**From:** Jared Romero, P.E., CFM, Development Review Engineer  
AMAFCA

**RE:** **AMAFCA COMMENTS FOR**  
**Pino Arroyo at the Foothills – LOMR dated 6/7/2023**

## AMAFCA Comments for Juan Tabo Hills Estates - LOMR

TITLE:
**THE FOOTHILLS
PINO ARROYO STA 10+00 - END**
CONCEPTUAL PLAN AND PROFILE

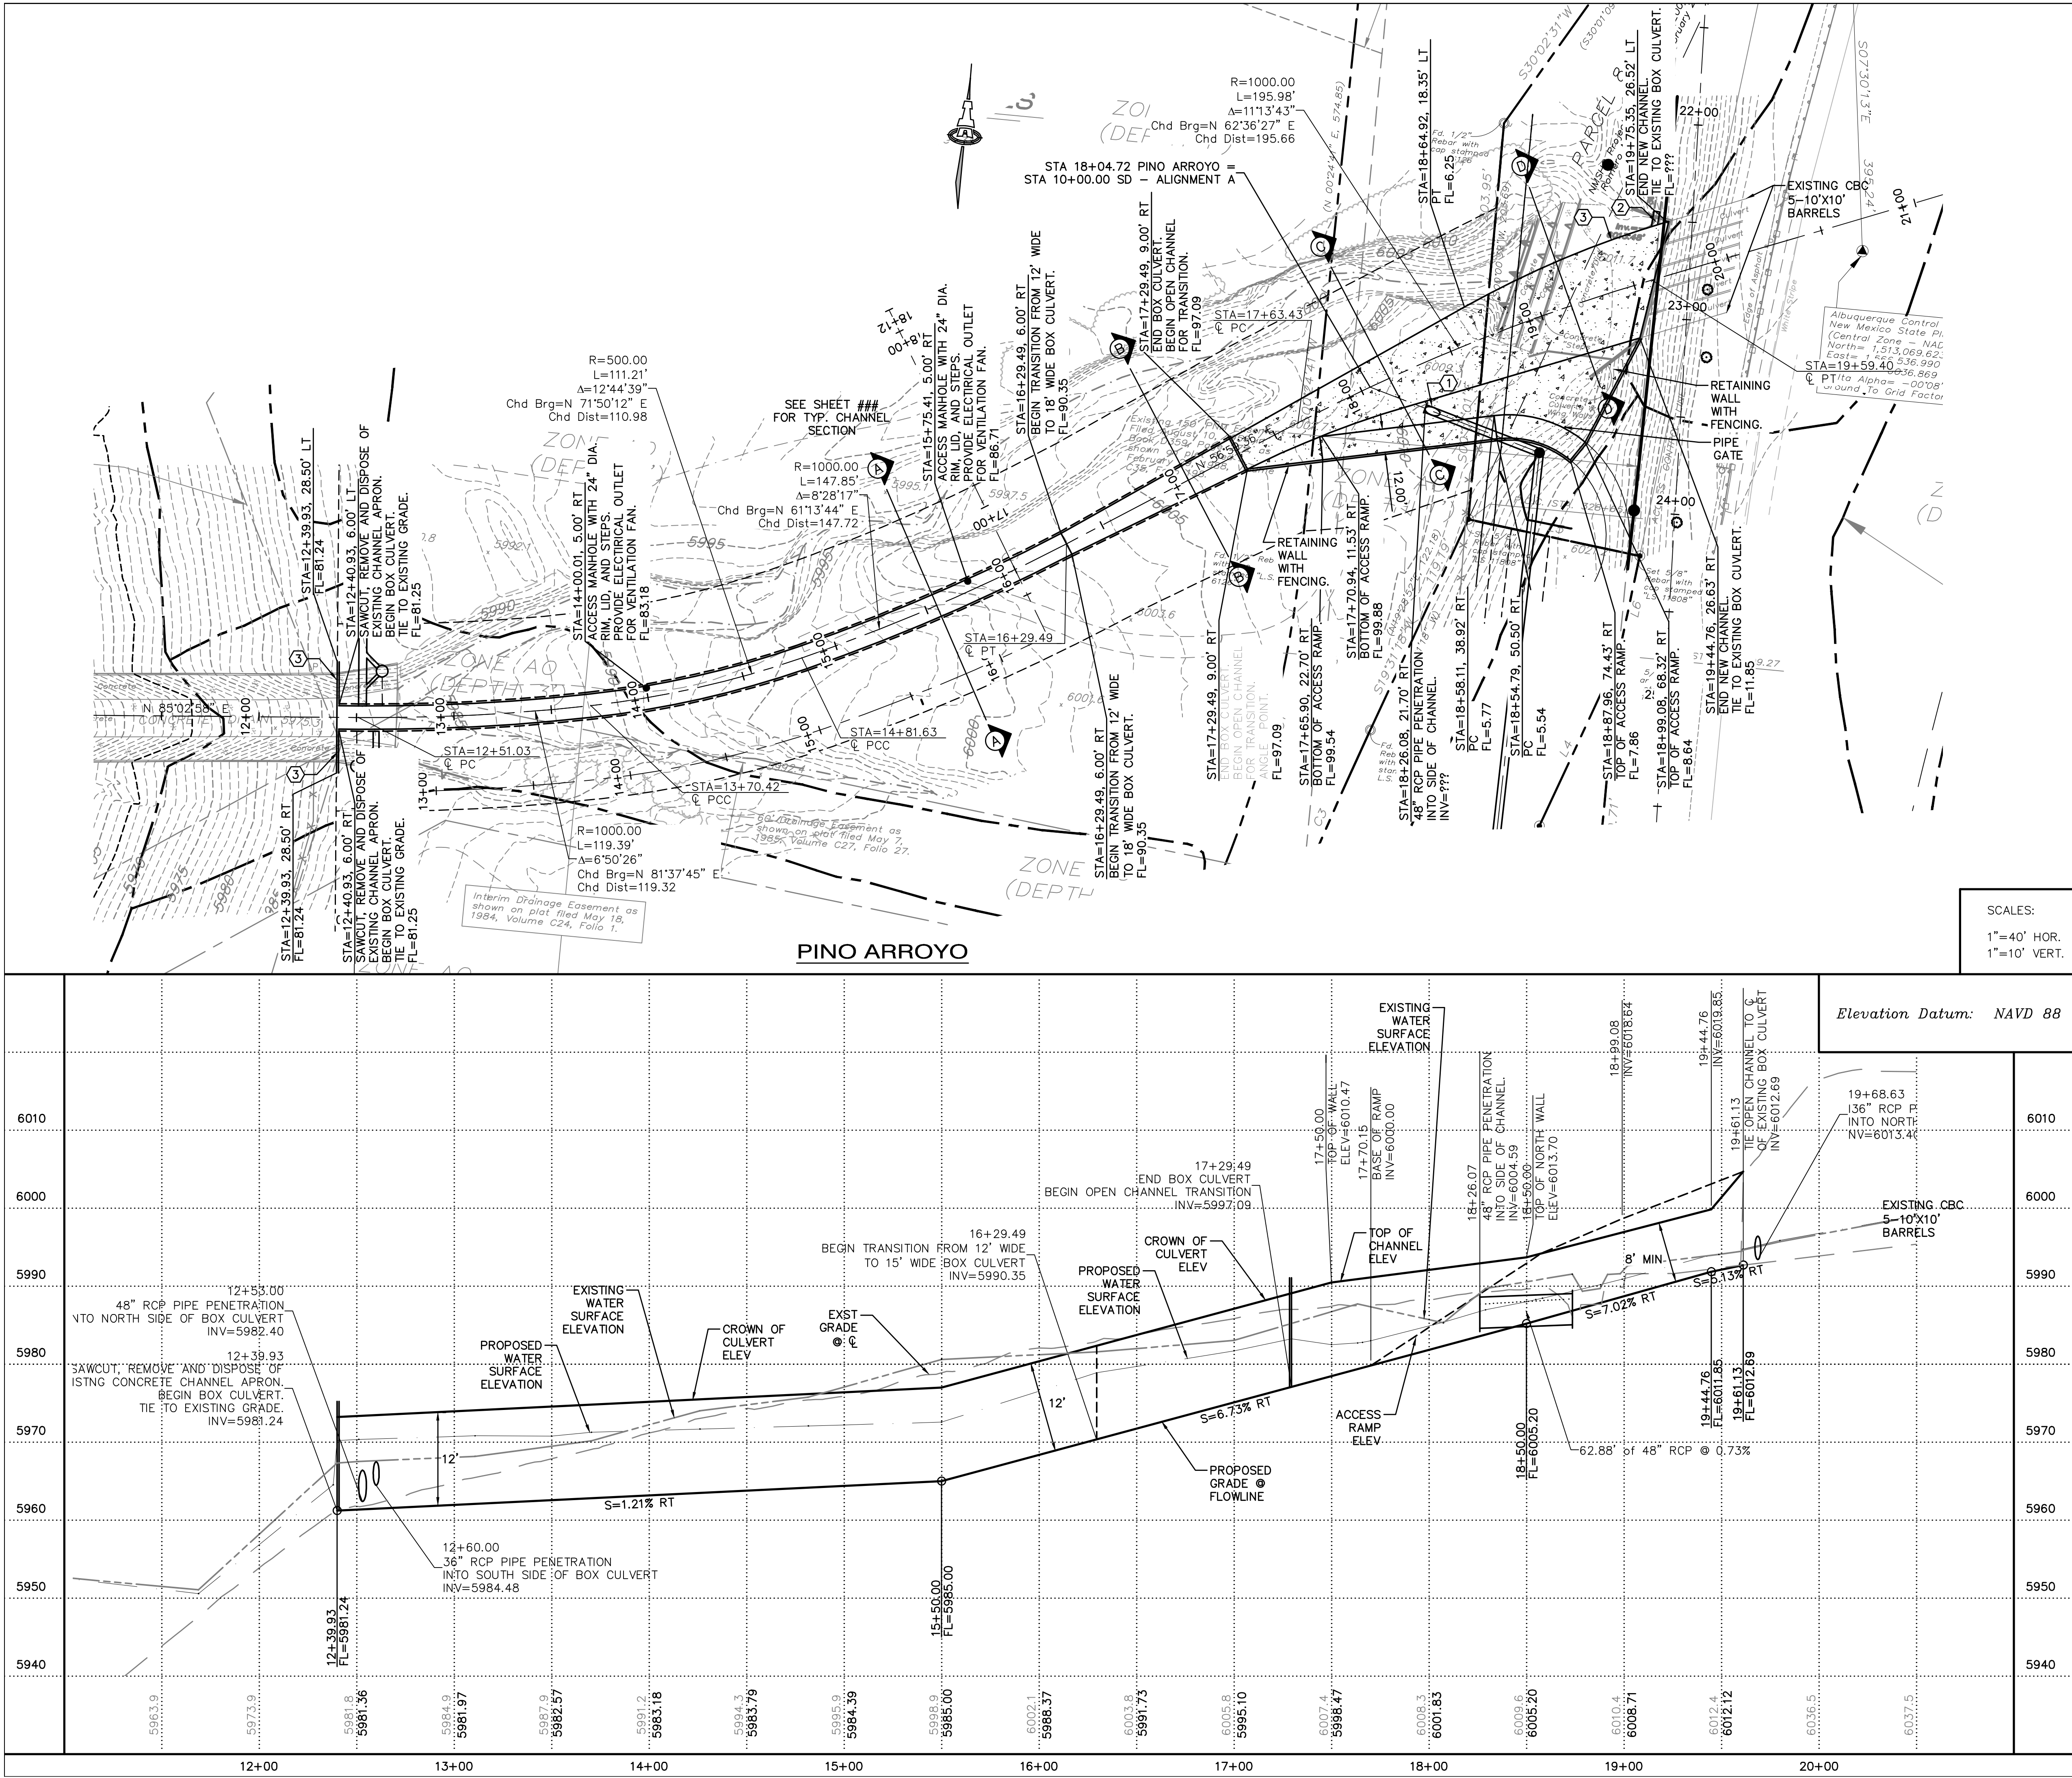
- There are several elevations in the HEC-RAS model that do not match the ground elevations in the as-built plans that need to be revised:
  - a. Channel connection to existing concrete rundown into Pino Dam: As-Built = 5977.82', Model = 5977.60'
  - b. Downstream headwall of CBC: As-builts = 5978.62', Model = 5978.60'
  - c. Grade Break in downstream CBC: As-builts = 5985.08', Model = 5985.00'
